An
Bord
Pleanála

**Inspector's Second
Addendum Report**

ABP-314019-22

Strategic Housing Development (SHD)	Demolition of the existing building on site, construction of 350 no. apartments and associated site works.
Location	Junction of Santry Avenue and Swords Road, Santry, Dublin 9 – occupying the site of the existing Chadwick Builders Merchants (www.santryavenueshd2.ie)
Planning Authority	Dublin City Council (DCC)
Applicant	Dwyer Nolan Developments Ltd.
Prescribed Bodies	<ol style="list-style-type: none">1. Irish Water2. DAA3. Transport Infrastructure Ireland4. National Transport Authority
Observers	34 no. as per the original Inspector's Report (IR) dated 2 nd December 2022

**Ground Floor Plan**  
 SCALE: 1:200

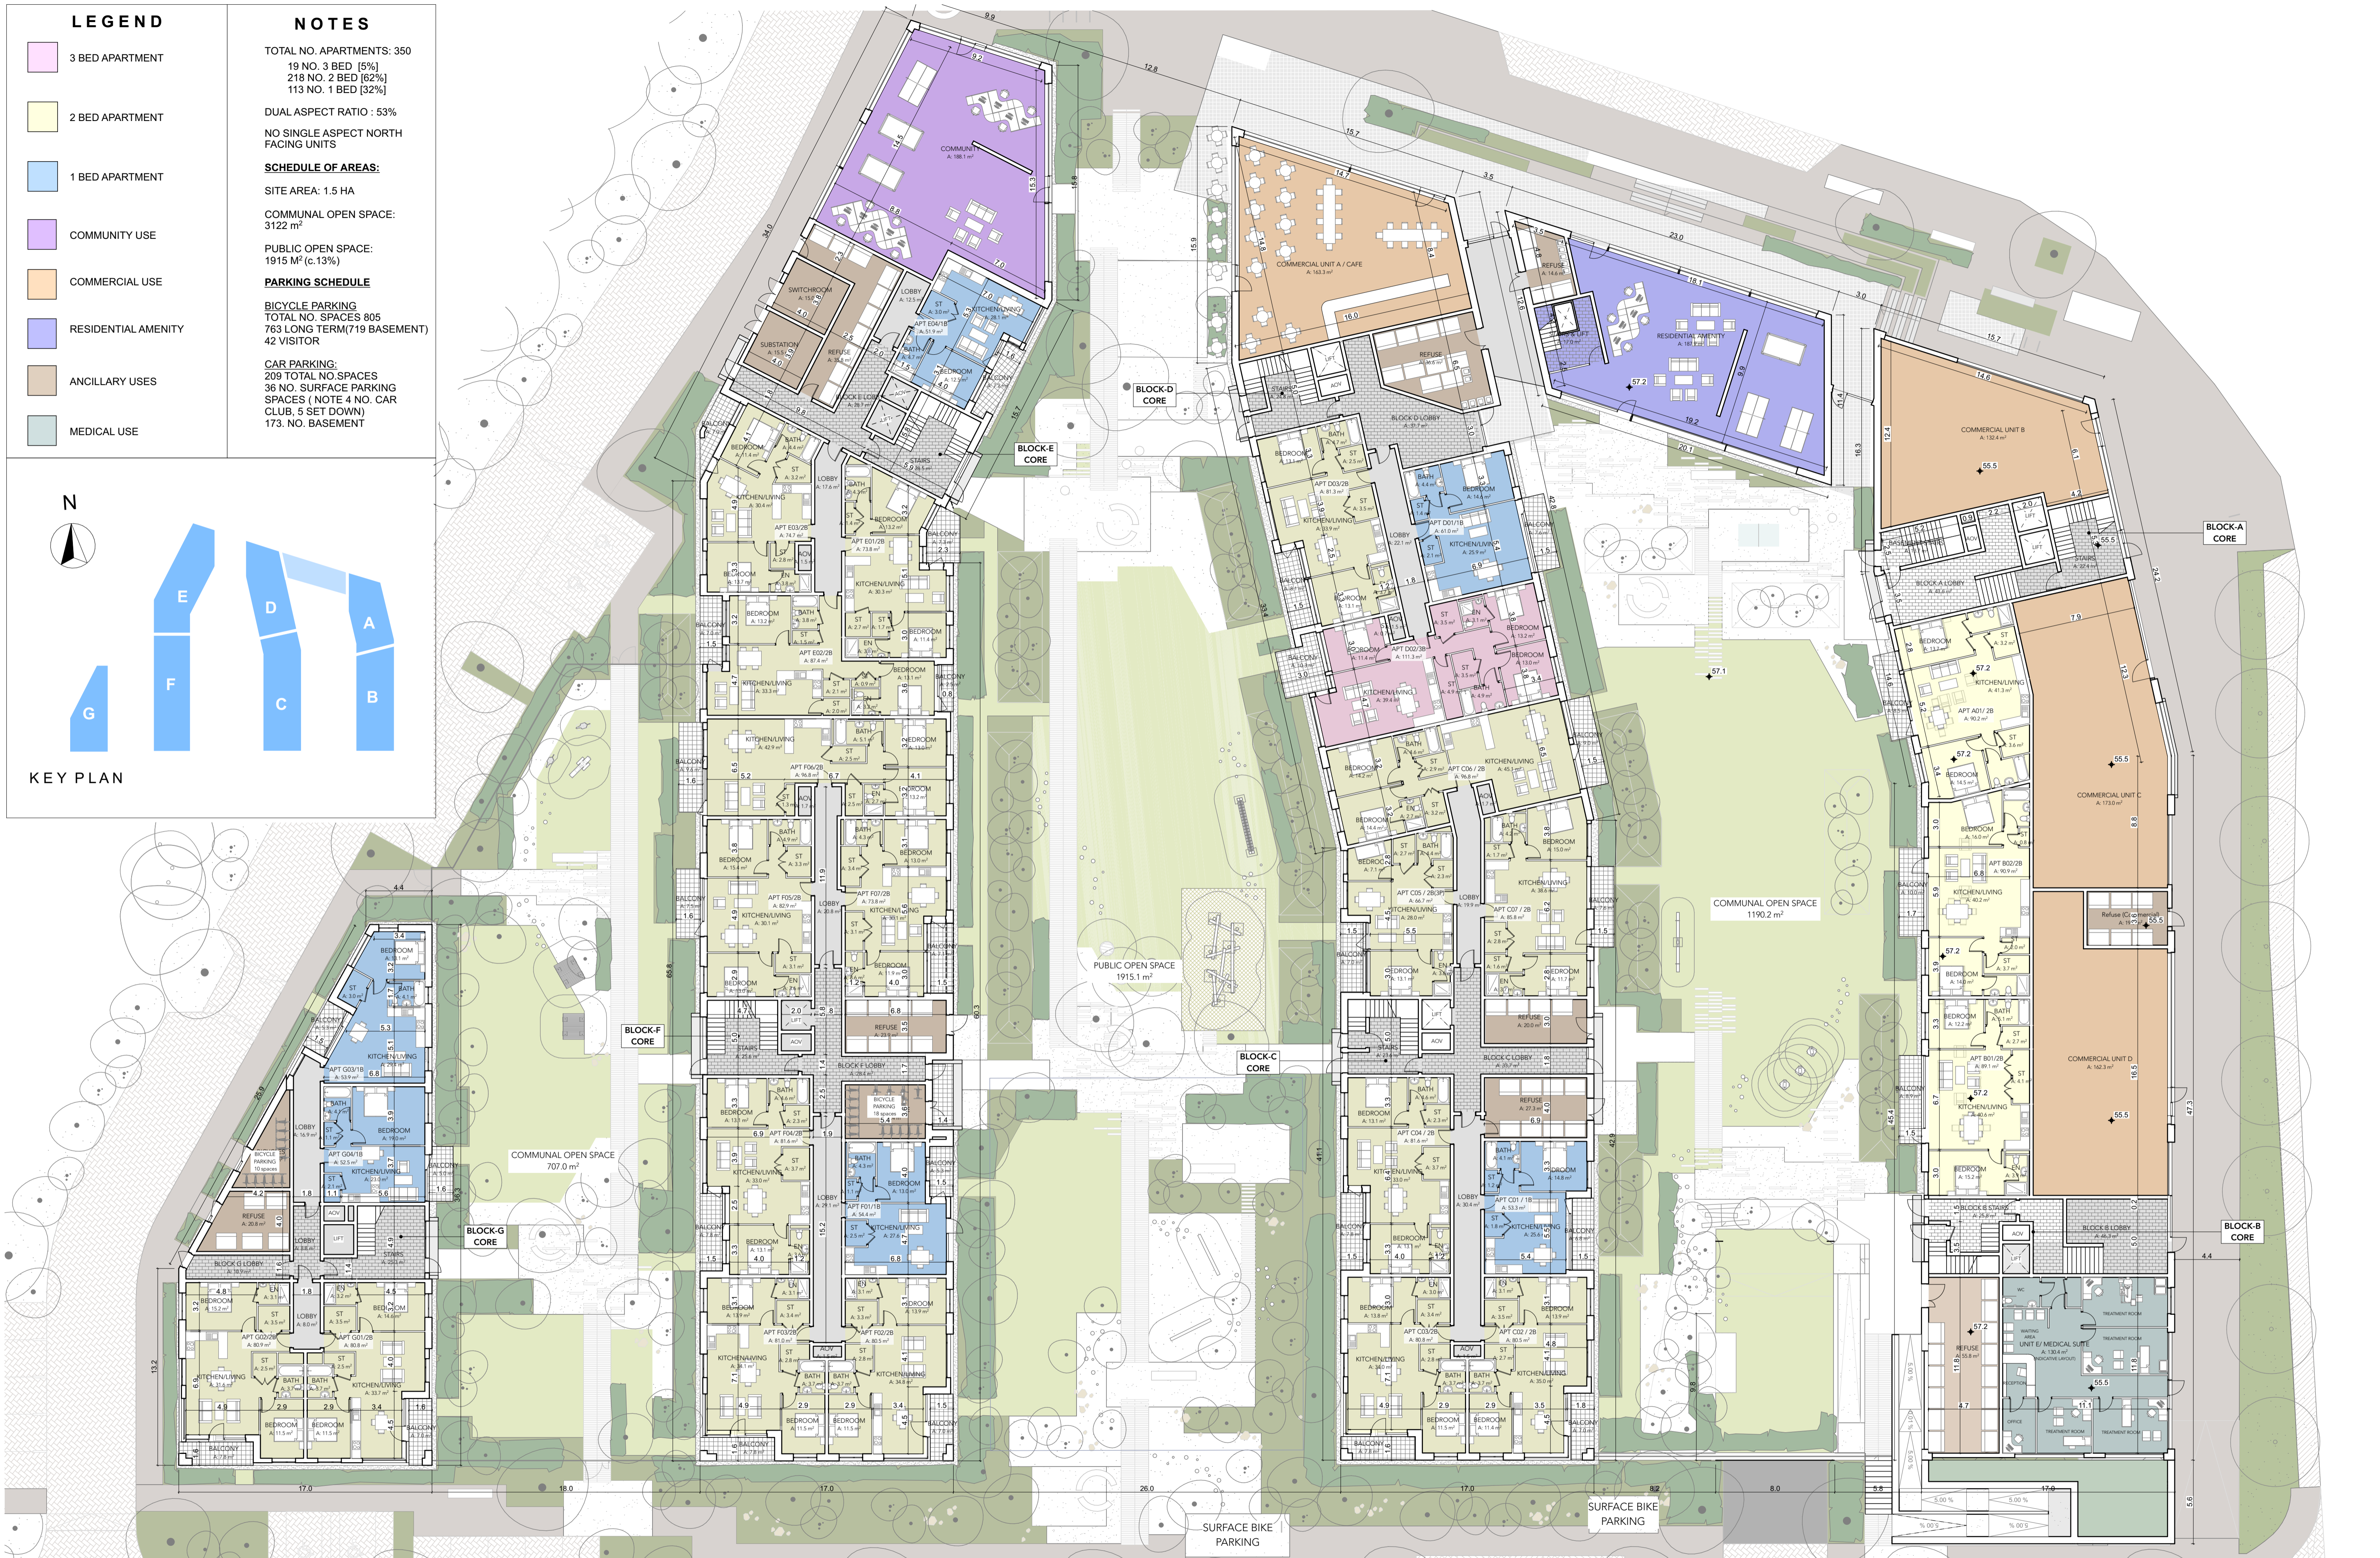
- 3.5. I described in paragraph 2.5.4 of the AR dated 18th November 2024 how the required community, arts, and culture space could be achieved, without a fundamental re-design of the proposed development, by replacing certain ground floor apartments with community, arts, and culture space. As part of the submission to the oral hearing, the applicant provided a revised ground floor plan which provided for the removal of 14 apartments and the provision of community spaces of varying sizes in lieu. This is illustrated on the 'Ground Floor Plan – Oral Hearing' drawing dated 27th February 2025 which accompanied the applicant's oral hearing submission. The updated ground floor layout is relatively similar, but is not identical, to that submitted as part of the permitted LRD application⁴.

- 3.6. The 14 apartments had a floor area of 1,144.7sqm which, when added to the 188.1sqm originally proposed as a community space, would result in a floor area of 1,332.8sqm for community, arts, and cultural space, in excess of the 1,324.4sqm required. The number of residential units in the SHD would reduce from 350 to 336. The floor area of the commercial units and communal spaces would not be affected.

- 3.14. As part of the limited agenda oral hearing submission the applicant provided a 'Ground Floor Plan – Oral Hearing' drawing dated 27th February 2025. I note that, although there are some elevational alterations to the affected floor areas as a result of the proposed changes of use⁵, no accompanying elevation drawings were submitted. I also note that the revised ground floor plan appears to allow users of the community spaces in Block F to access communal open space between Blocks F and G via external doors/ground floor balconies. In the interest of security I consider that no access to private/communal areas should be permitted and all community use areas should only be accessible via public areas. I consider that it would be appropriate to include a condition to any grant of permission that revised elevations for Blocks C, D, E, and F are provided together with a floor plan showing all access points to the various community spaces accessible only through public areas.

- 3.8. I consider that the revisions to the ground floor, proposed as part of the applicant's submission to the oral hearing, are sufficient to address objective CUO25 of the DCDP 2022-2028. The proposed development would have a minimum 5% of the floor area being provided for community, arts, and culture use and an appropriate cultural audit has been submitted as required by objective CUO30.
